From: Contact Centre (CRM) <contact@ribblevalley.gov.uk>
Sent: 20 August 2024 22:44
To: Planning
Subject: Planning Application Comments - 3/2024/0613 FS-Case-640185330

Planning Application Reference No.: 3/2024/0613

Address of Development: Inglemead Waddington Road Clitheroe

Comments: We have the following comments about planning application number 3/2024/0613- proposed demolition of existing single garage and construction of new single storey two bedroom dwelling (Self build) at the end of the rear garden of Inglemead, Waddington Road, Clitheroe BB7 2HN.

proposed floor plan & elevations

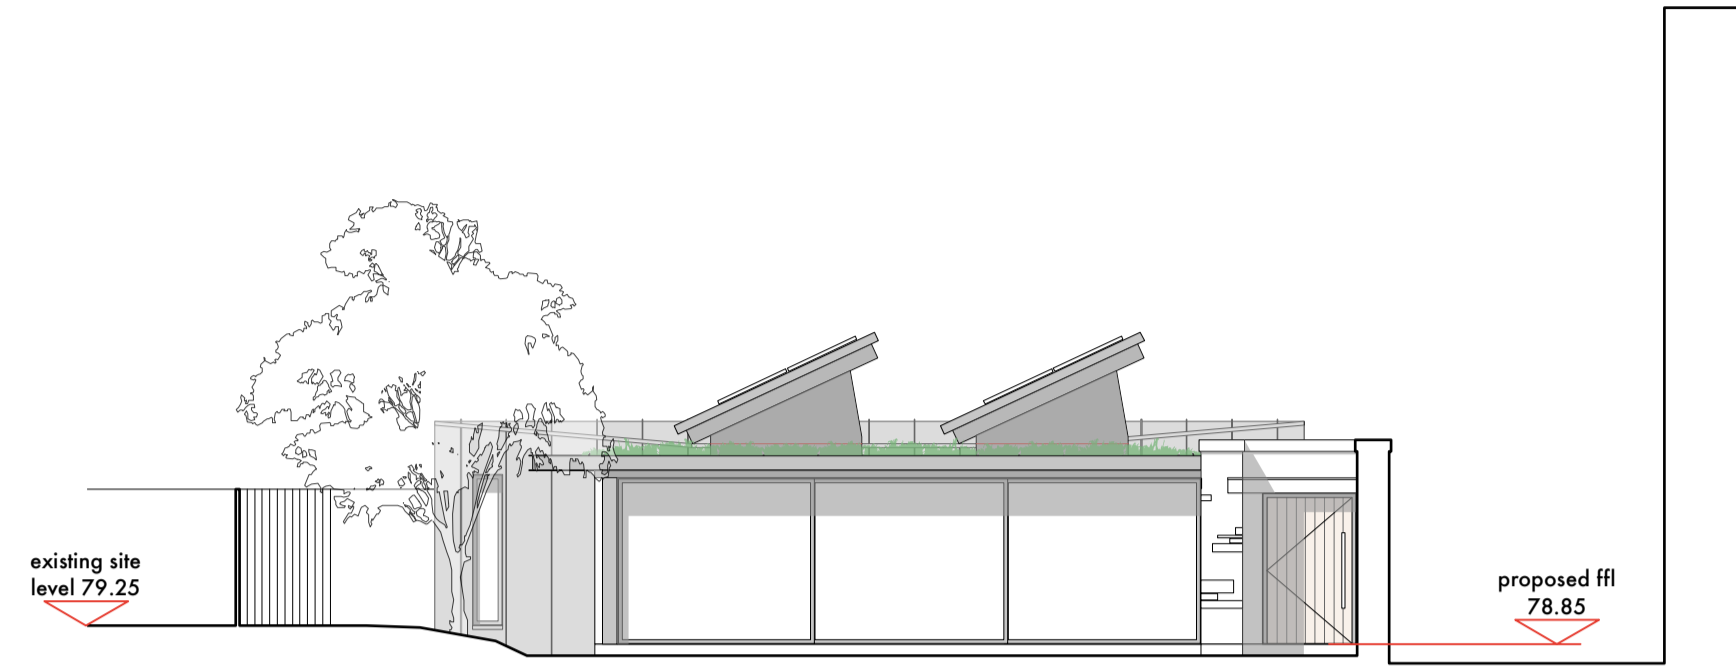
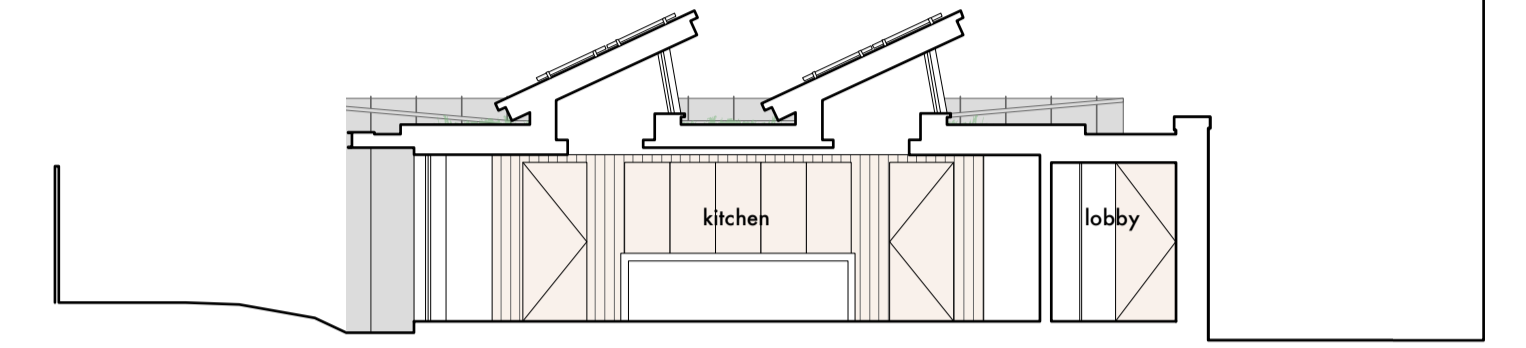
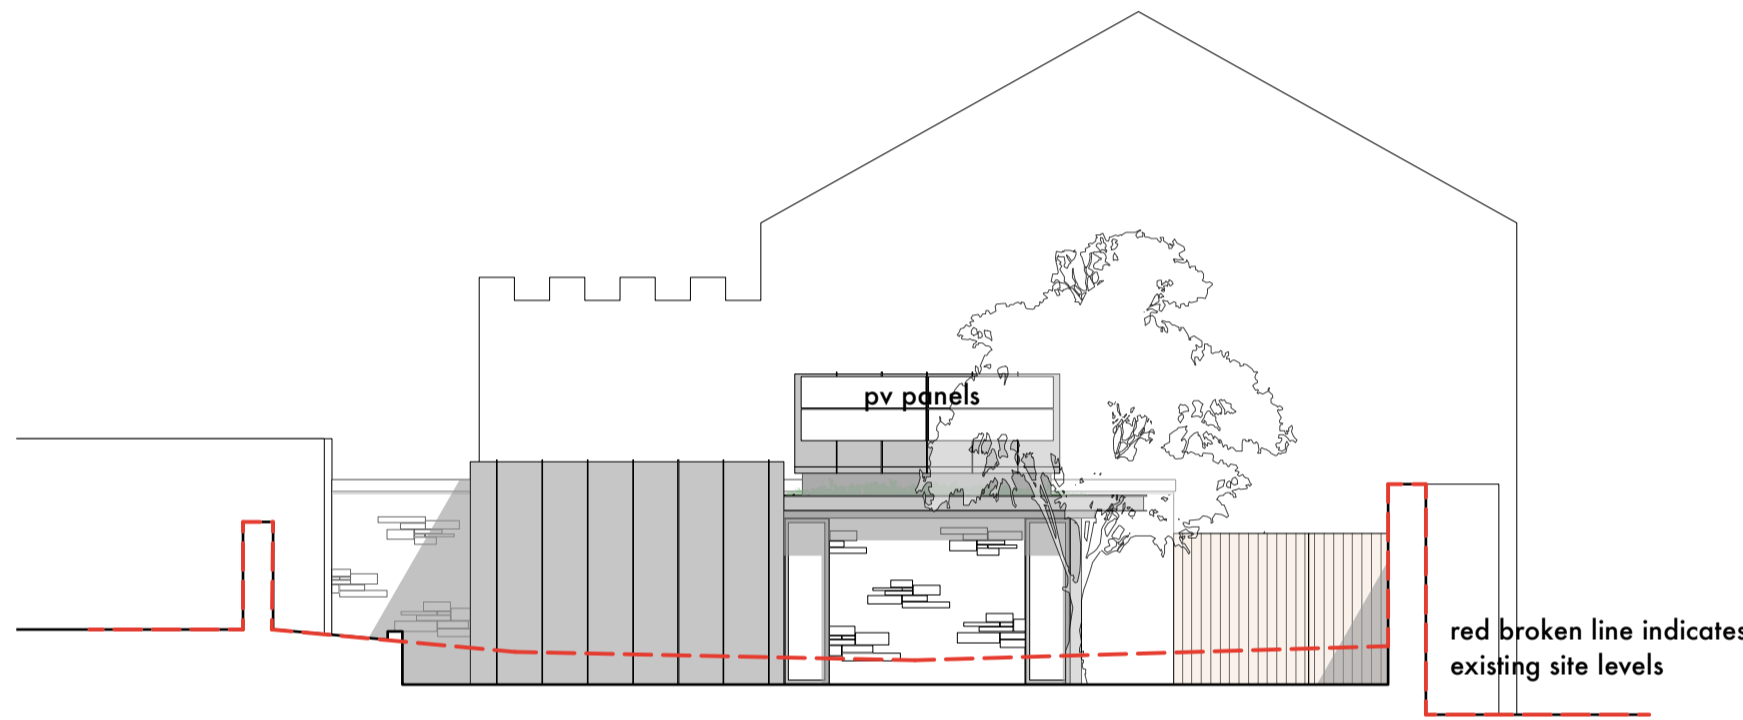
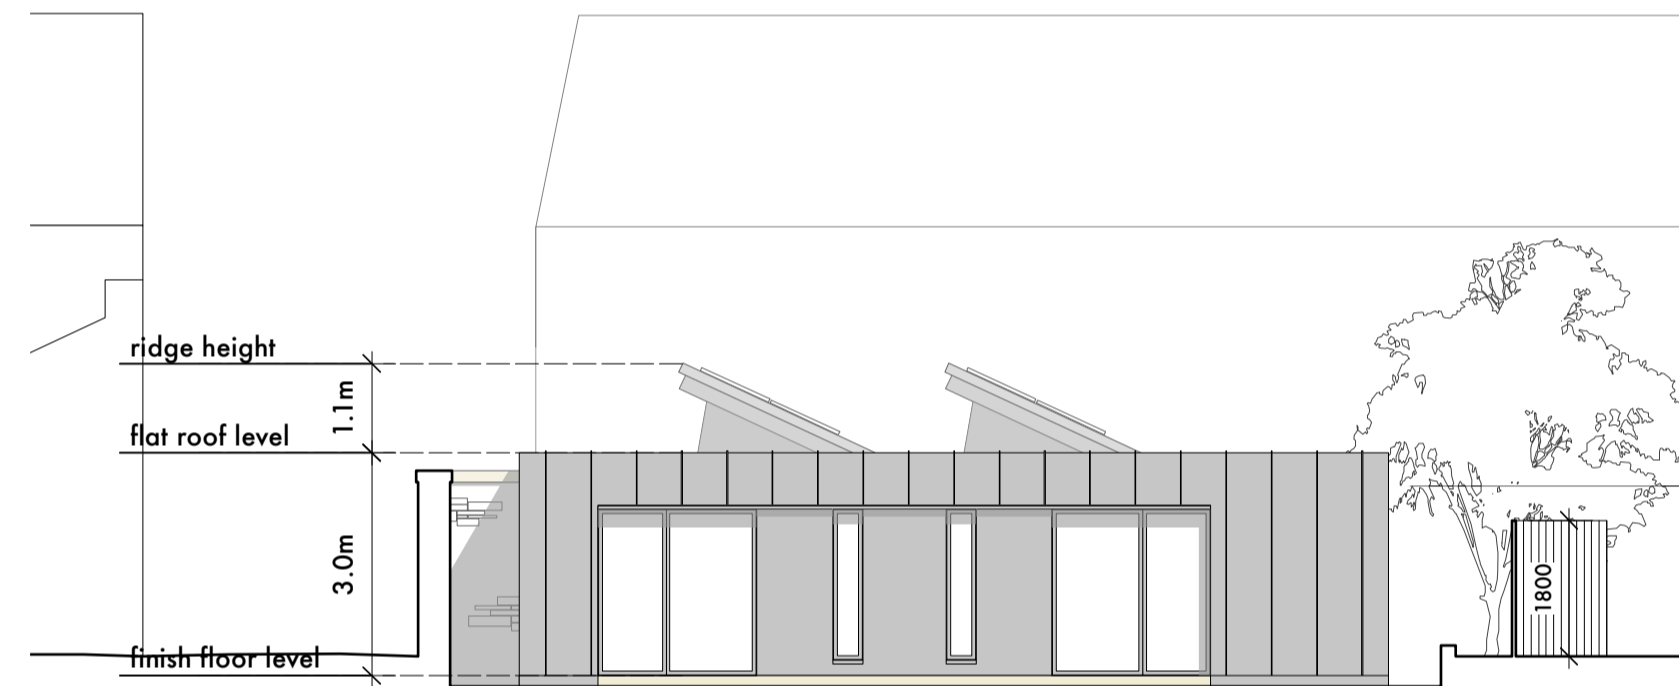
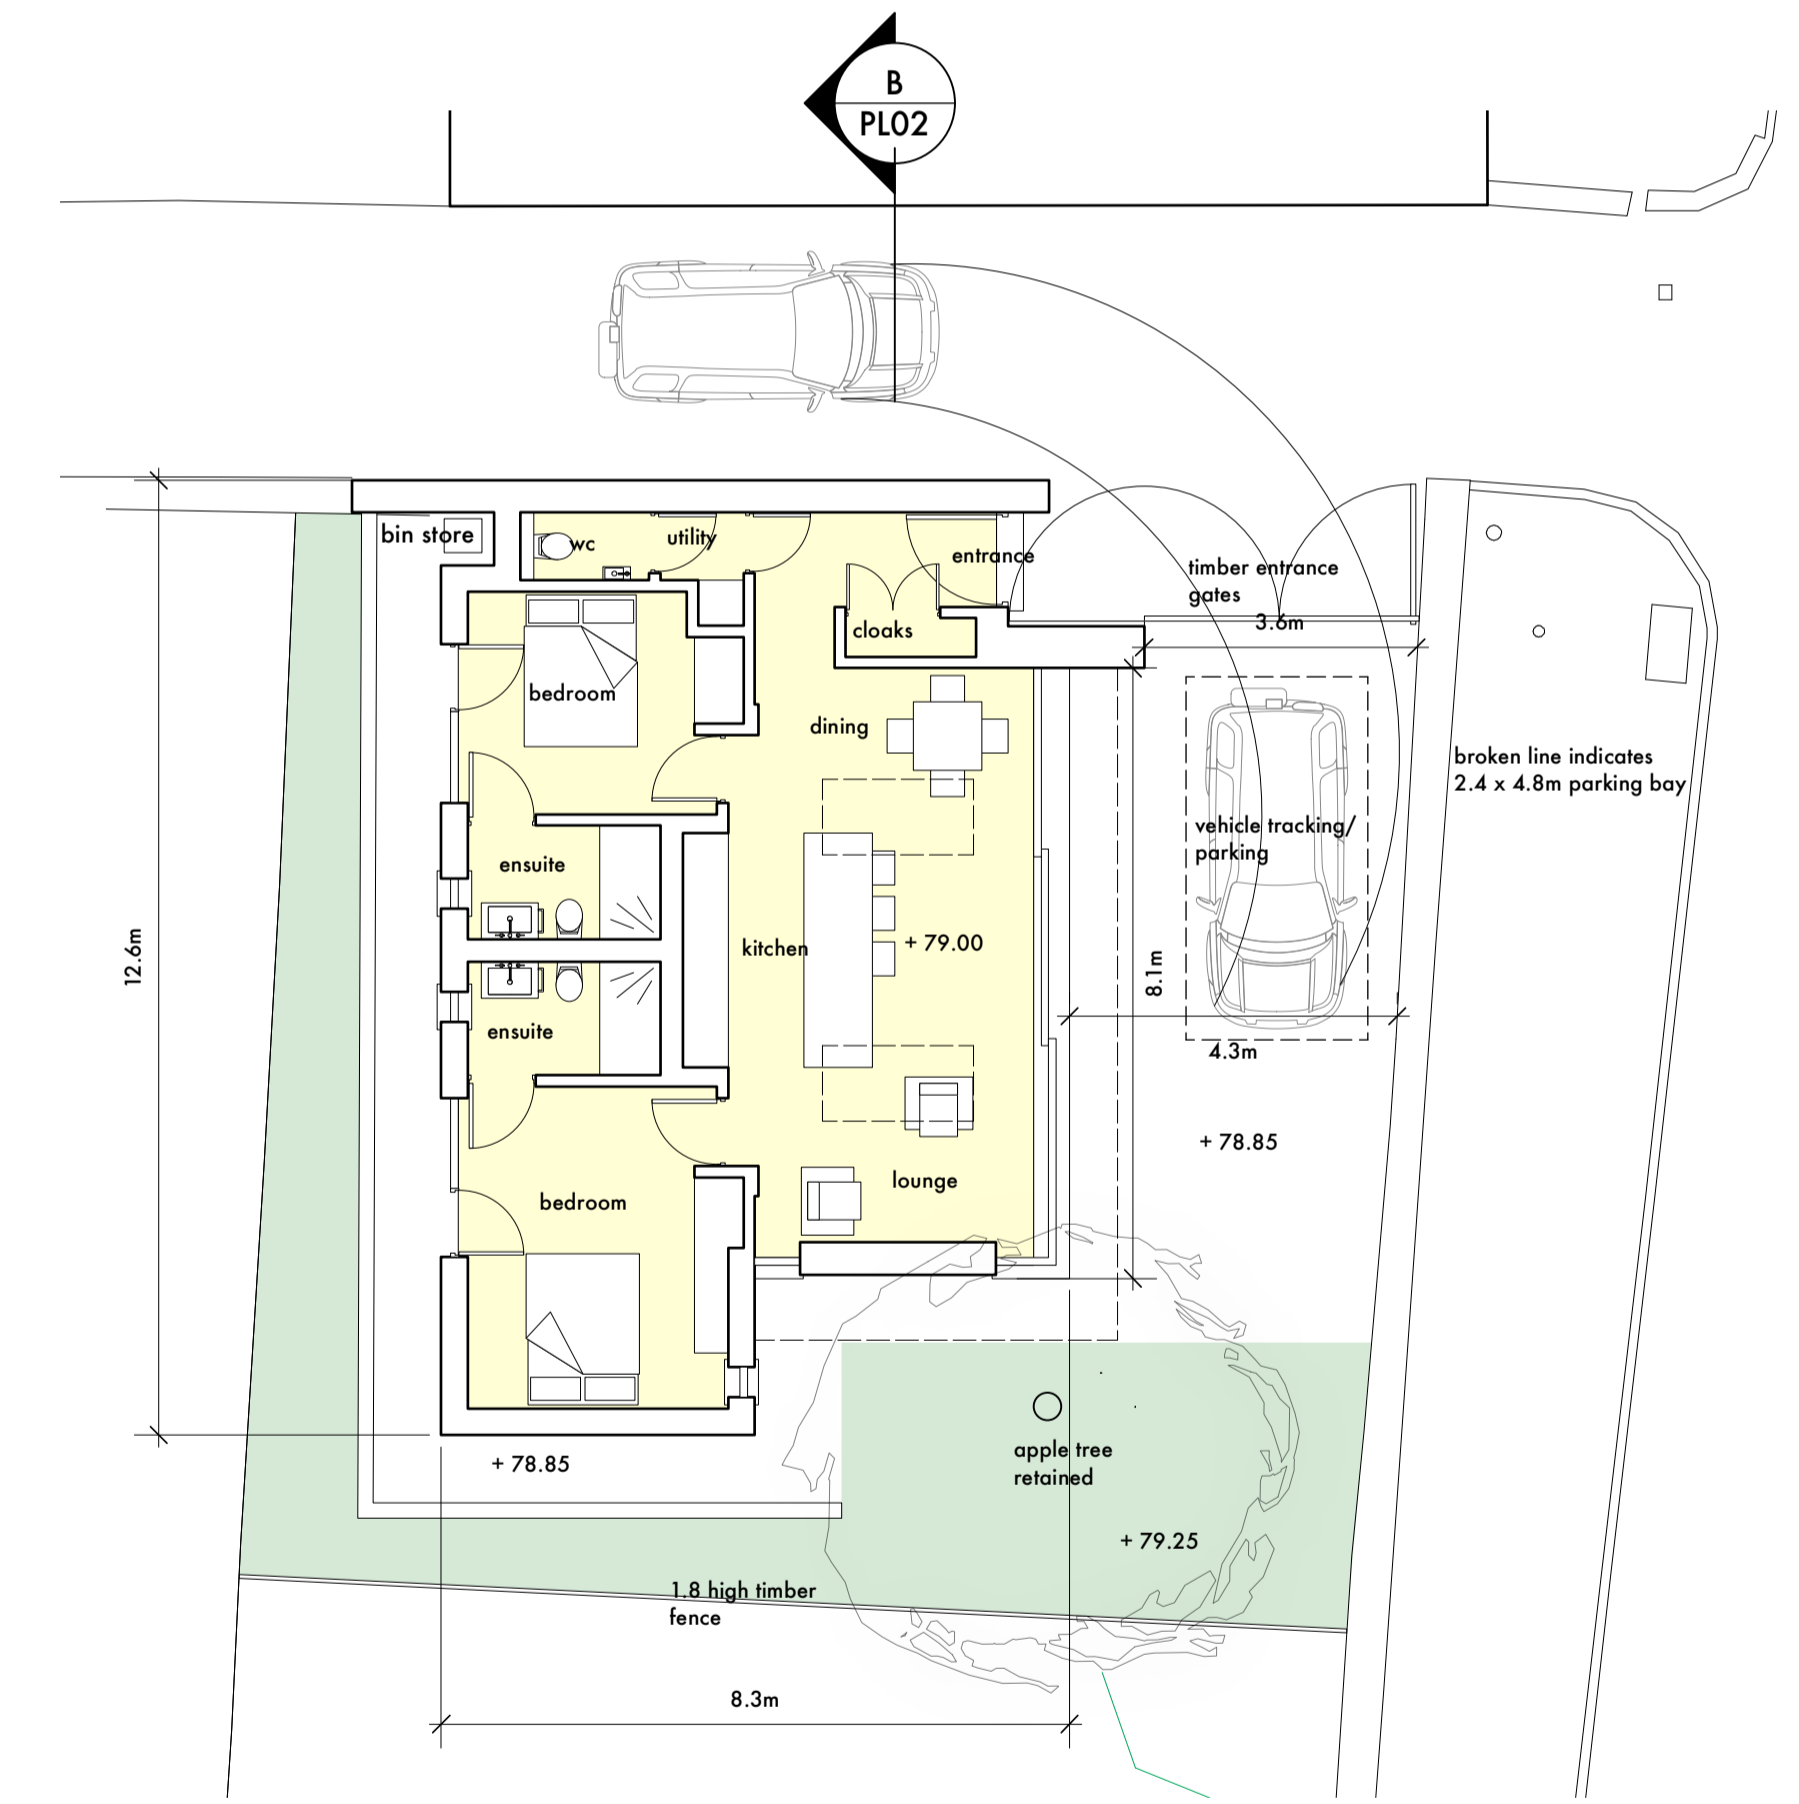
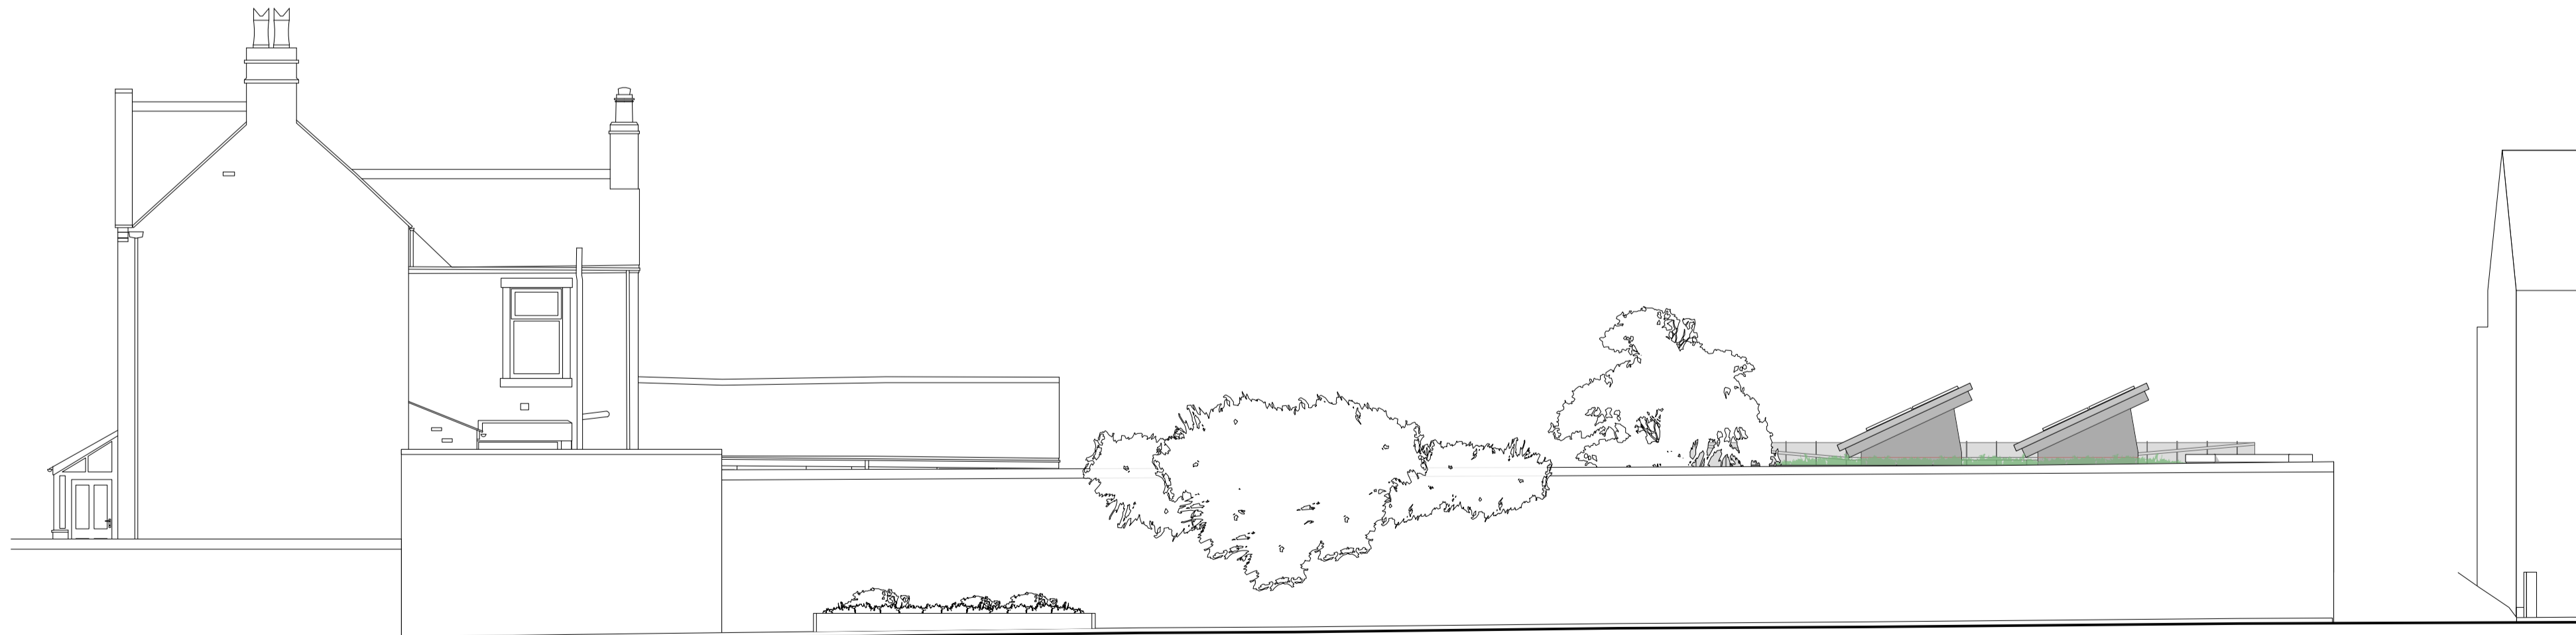
Although we appreciate that the applicant may be wishing to use mixed materials for the building as a feature, this is not in keeping with surrounding dwellings which are in a traditional style. We would suggest all the building is of coursed stone [REDACTED].

Whilst we appreciate the ecological benefits of the flat sedum roof and the fact that this is low and expected to be hidden behind the higher wall, again this is not in keeping with surrounding property styles. The sedum roof is a minor gesture compared to the loss of flora and fauna caused by building's erection. It also needs a lot of maintaining to ensure that after a short period of time it does not die exposing unattractive under material or become out of control with tall weeds. Two roof lights/solar panels which are over a metre high are also unsightly.

The standing seamsheet metal is not at all in keeping with surrounding properties or Inglemead and would stand out as such. One appreciates that the manufacture of zinc may be more environmentally friendly than other metals, but reclaimed stone would be more so, as would a reclaimed slate roof and would also be more natural materials, as is fitting for the age and style of the surrounding

The close boarded long wooden fence dividing the garden from Inglemead is not particularly attractive from any aspect and we would suggest that the walled Victorian garden theme is maintained. If this barrier is to be erected, it should be constructed of coursed or random stone with appropriate planting on either side. A close boarded high fence of 14.7m length and 1.8m high

The building would cast shadow [redacted] Inglemead. [redacted] building is 3m high at its lowest point [redacted].
